June 3, 2016

Bayside Bowl

Permit Review Comments Responses

4 EAST STAIR WALL MEETS ROOF (LOWER PORTION)
1/12" = 1'-0"

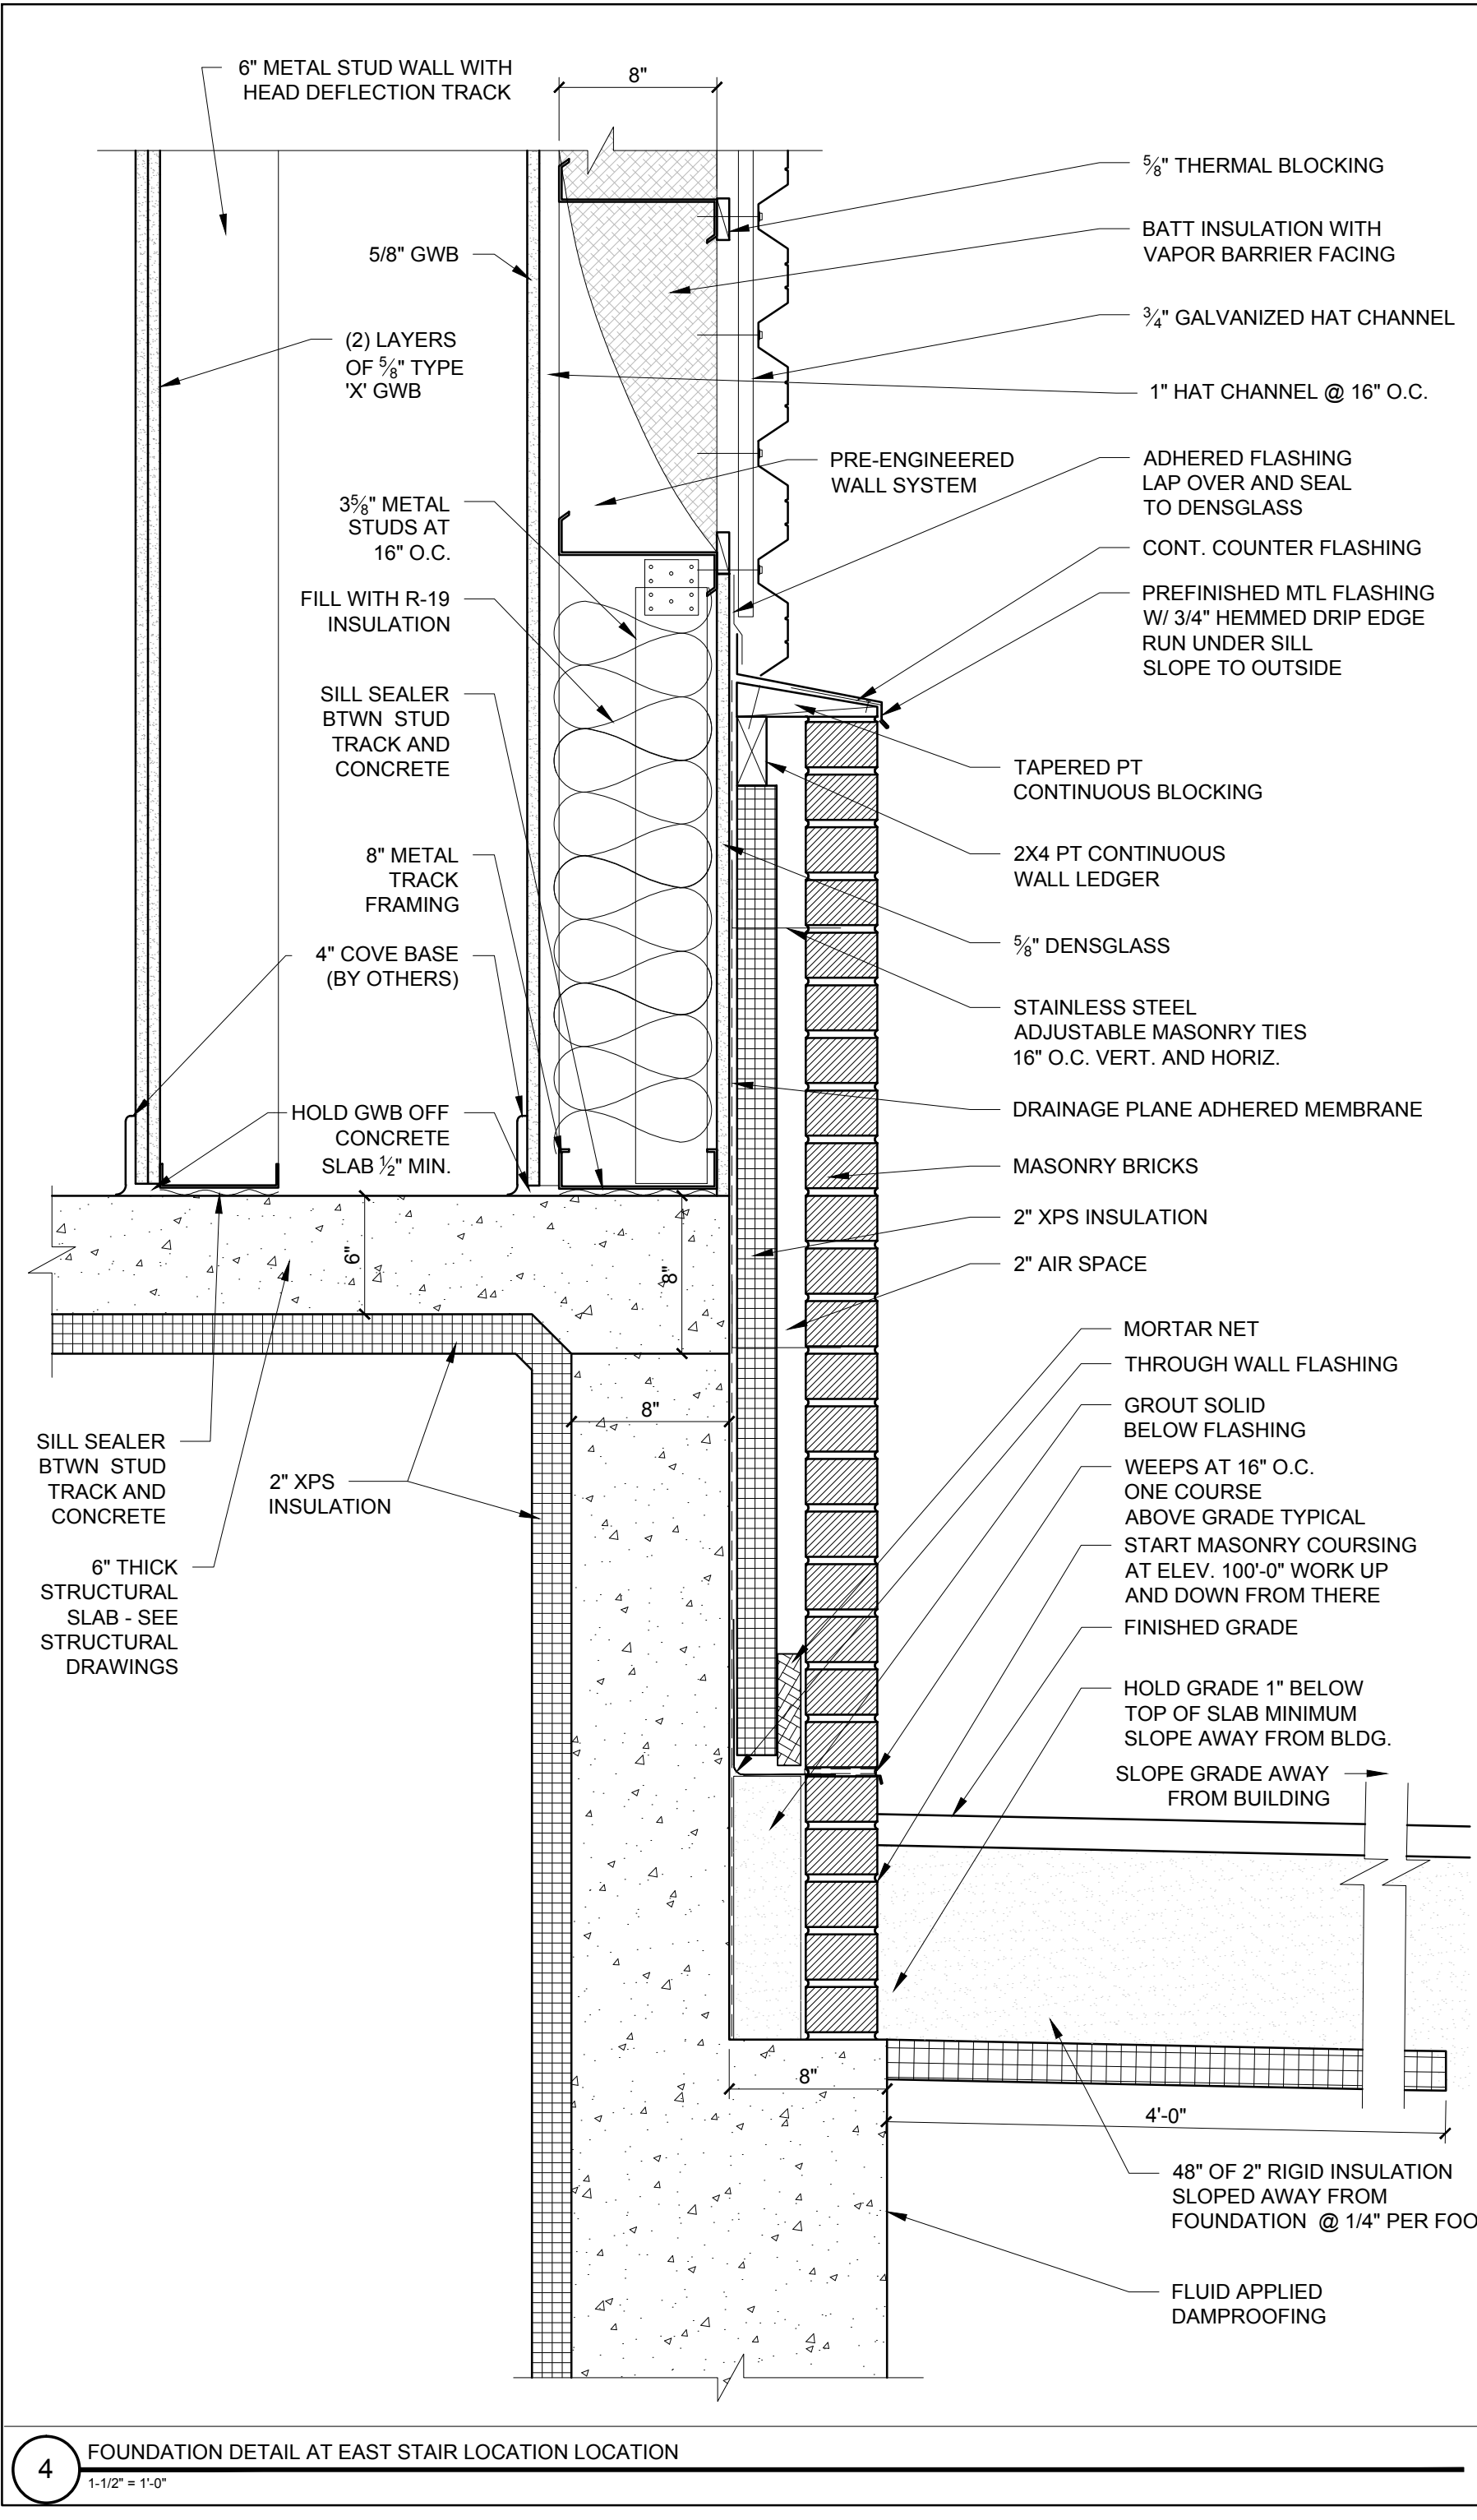
- 5.) A5-8, please see the revised sheets A5-1, A5-5, A5-6, A5-7 and A5-8 showing Fire treated roof blocking in lieu of PT blocking.
- 6.) A5-4, the detail was incorrectly tagged it is corrected as Detail 4/A5-2 on the attached sheet.
